Rezoning Transportation Analysis

Petition Number: 2021-094

Date	Description
08-25-2021	First Review (LH)
09-17-2021	Second Review (WB)
10-26-2021	Third Review (WB)

**RZ1.0**

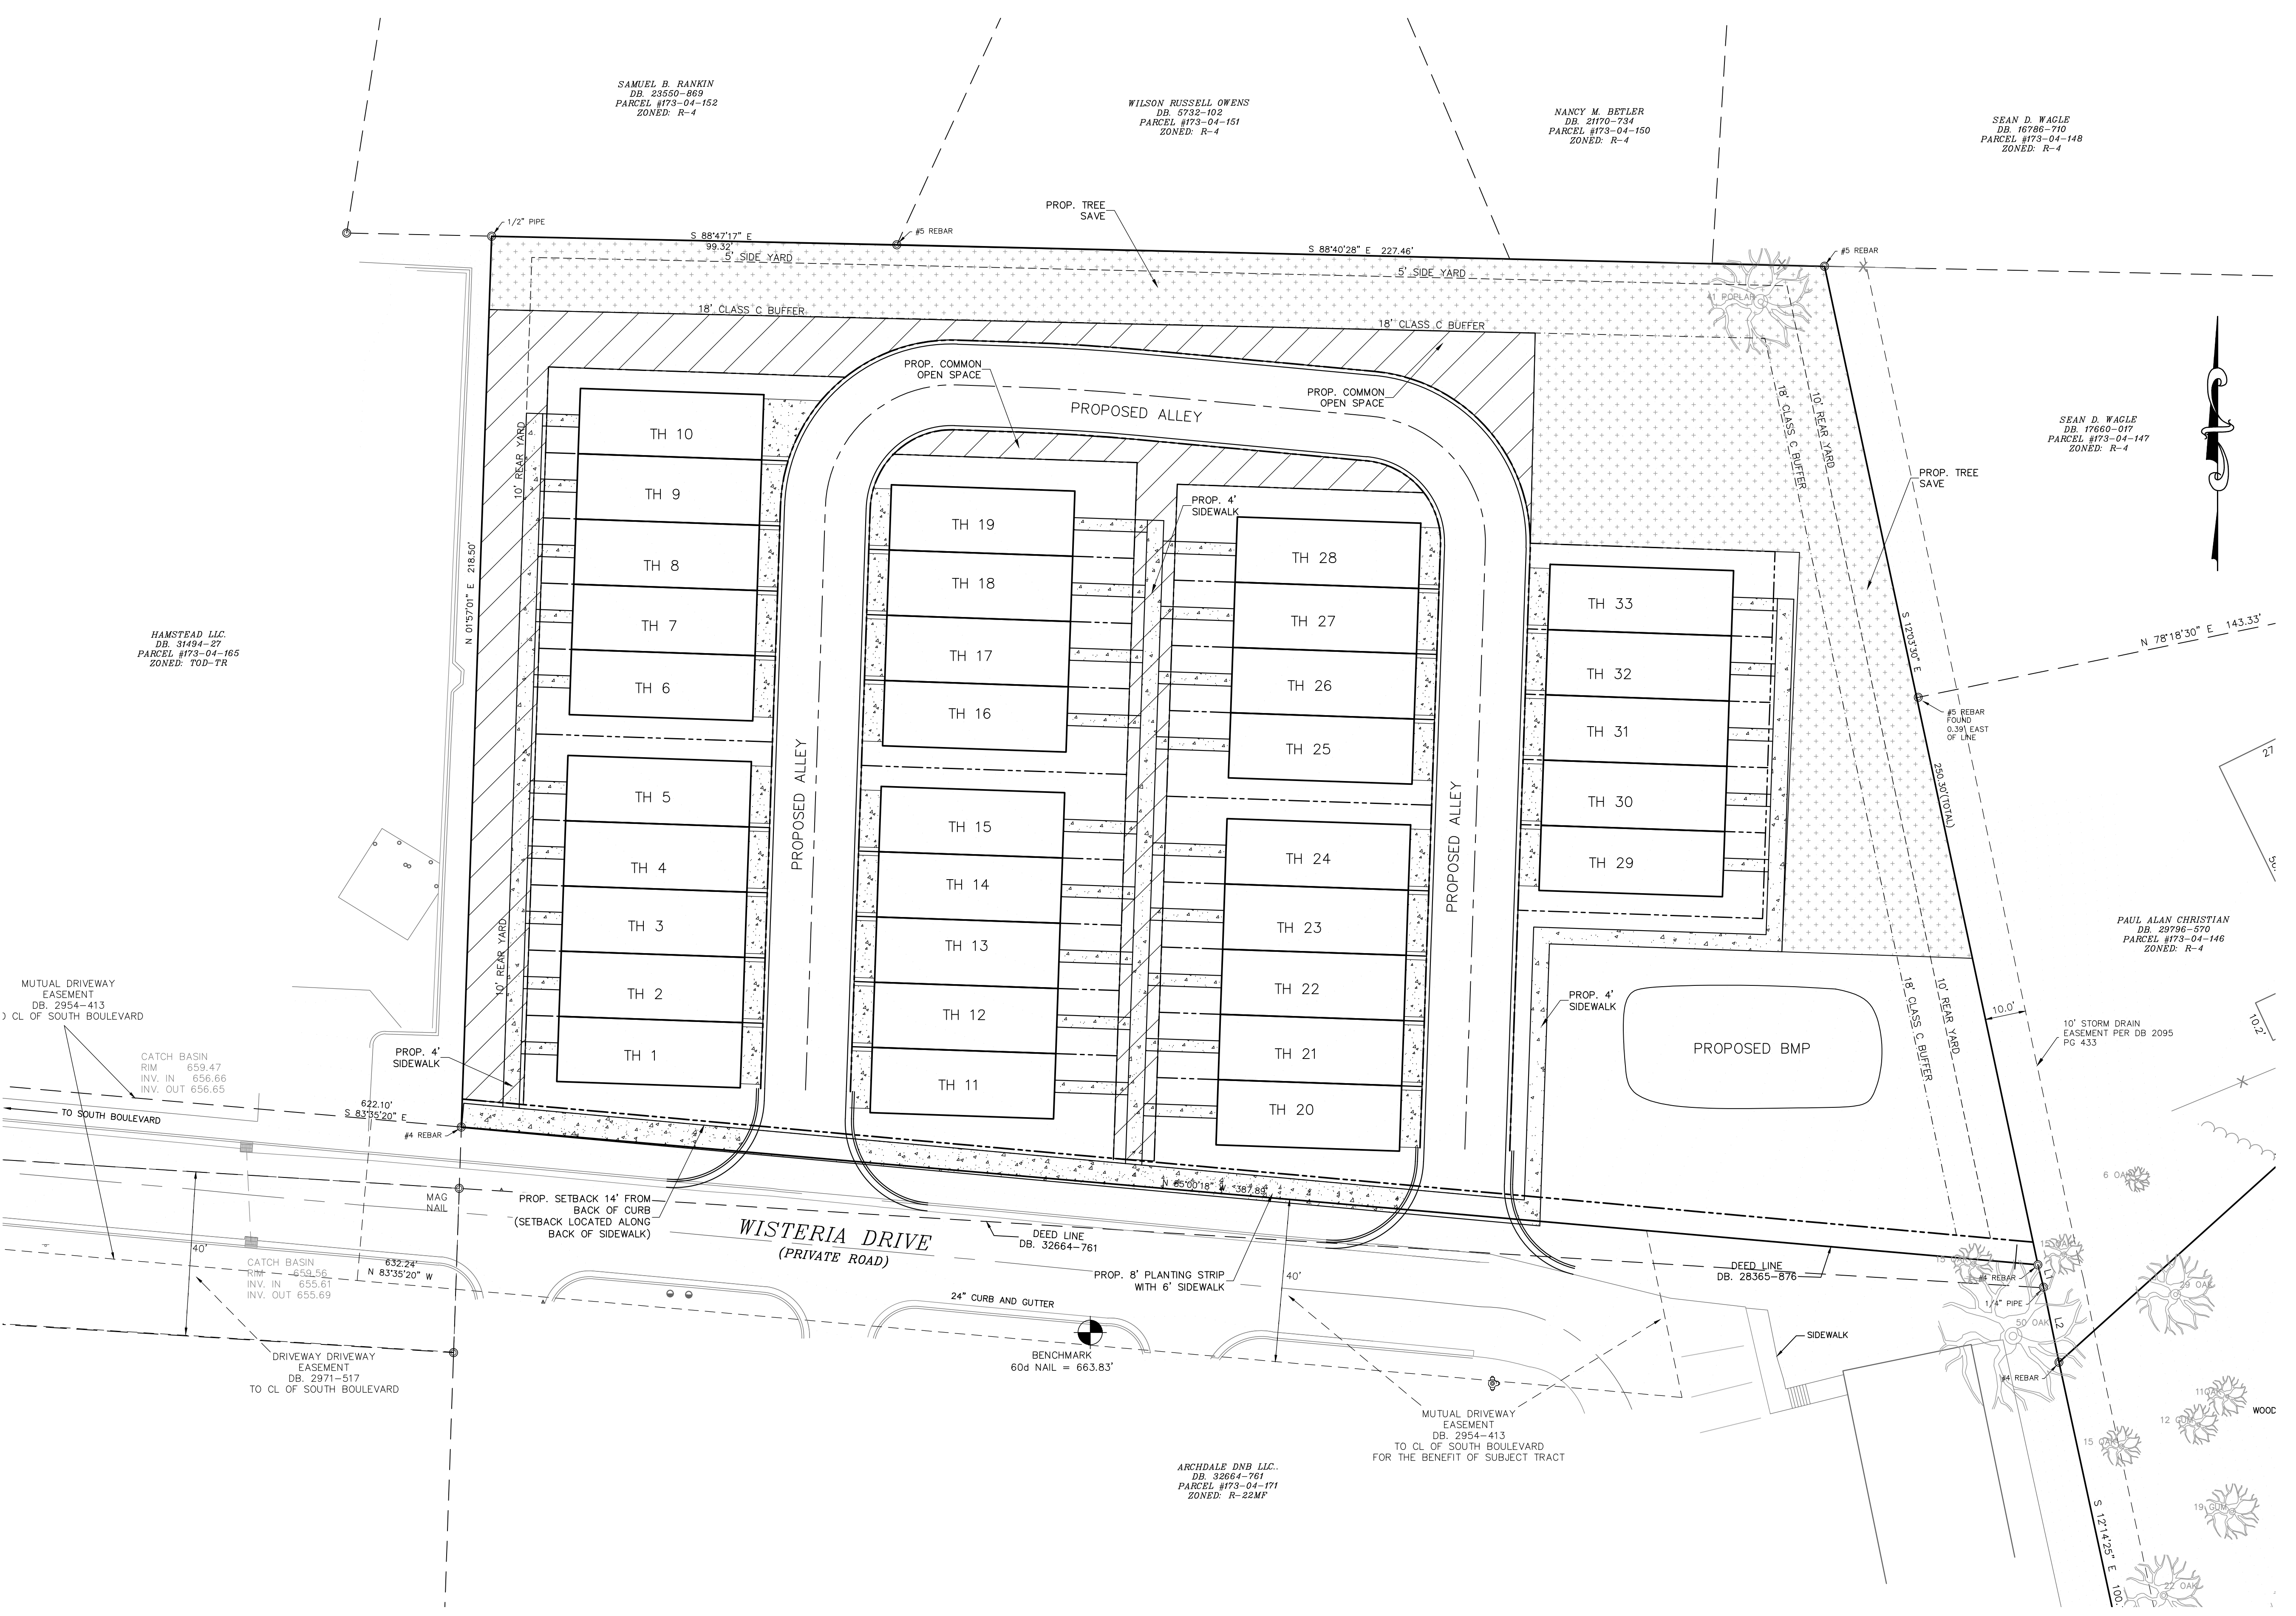
- ~~1. **Curbline:** The proposed zoning district has a setback measured from back of the existing or proposed future curbline.~~

~~**Wisteria Drive:** The future location of curb and gutter is in its existing location.~~

- ~~3. **Revised Site Plan Conditional Note E. Streetscape and Landscaping (2)** for the sidewalk utility easement to include 2' behind back of sidewalk, where feasible.~~

- ~~4. A site plan note specifying that all transportation improvements will be approved and constructed before the site's first building certificate of occupancy is issued is needed. The petitioner may phase transportation improvements if said improvements and phasing are explicitly described in site plan notes.~~
